## HYNLONG PTY LIMITED

19 March, 2013

**Re: Southlands Remediation and Development Project  
Modification under S.75W of Project Approval 06\_0191**

SOUTHLANDS FLOODPLAIN MANAGEMENT STRUCTURES
SCALE: 1:500

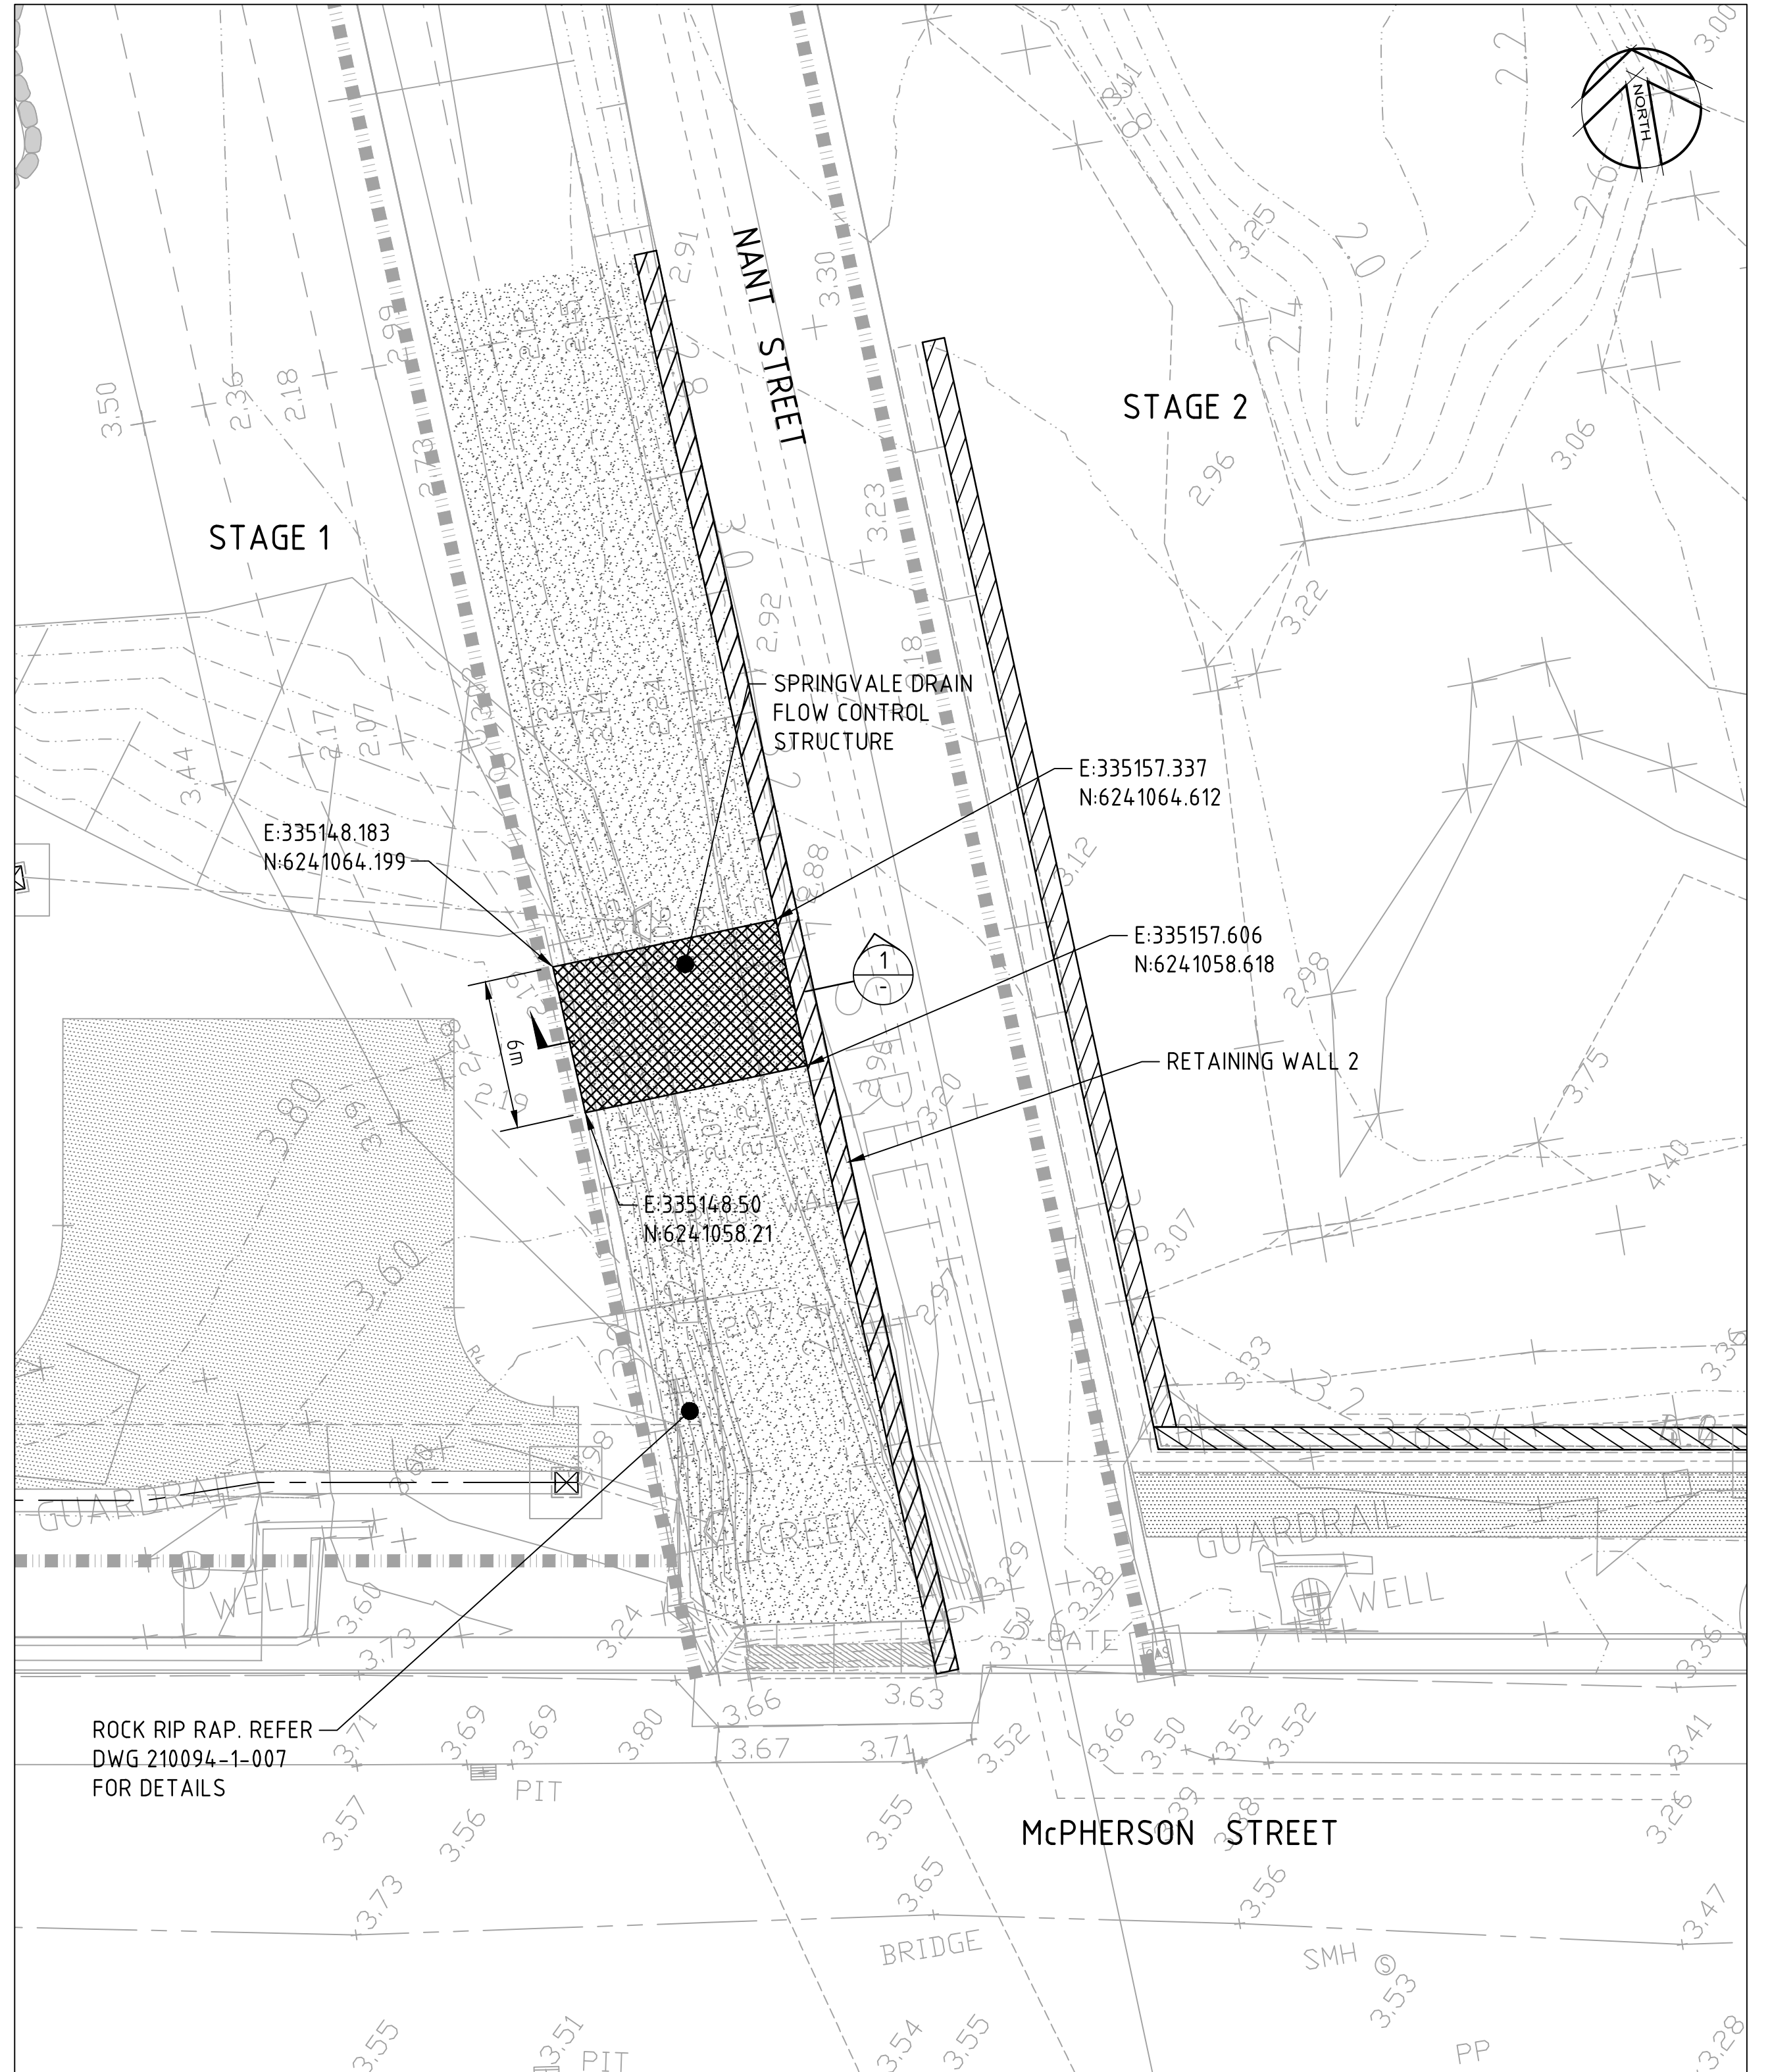
We refer to the second bullet point on page 3 of the Aurecon letter / report. We  
strongly object to the "hydraulic outlet" from the flood control basin being a "natural  
channel constriction" "in place of a weir structure". A natural channel can easily be  
altered by erosion, maintenance activities, or inadvertent re-grading. This can cause  
additional flooding impacts on our site in the future.

Furthermore, this flow control structure must not only be located within the banks of  
Springvale drain but must extend to all locations which are below the nominated  
flood level of RL4.2 through which flood waters may pass. For example, on the  
McPherson St frontage, it should extend either side of the Springvale drain channel  
from the western building platform (Min RL 4.8) to the eastern flood control "Wall"  
(RL 4.5).

*f) The hydraulic outlet from the flood control basin must be a permanent defined concrete structure so that it will remain unaltered over time. The structure shall be located within Springvale drain and shall extend to all locations which are below the nominated 100 year ARI flood level of RL4.2 through which flood waters may pass.*
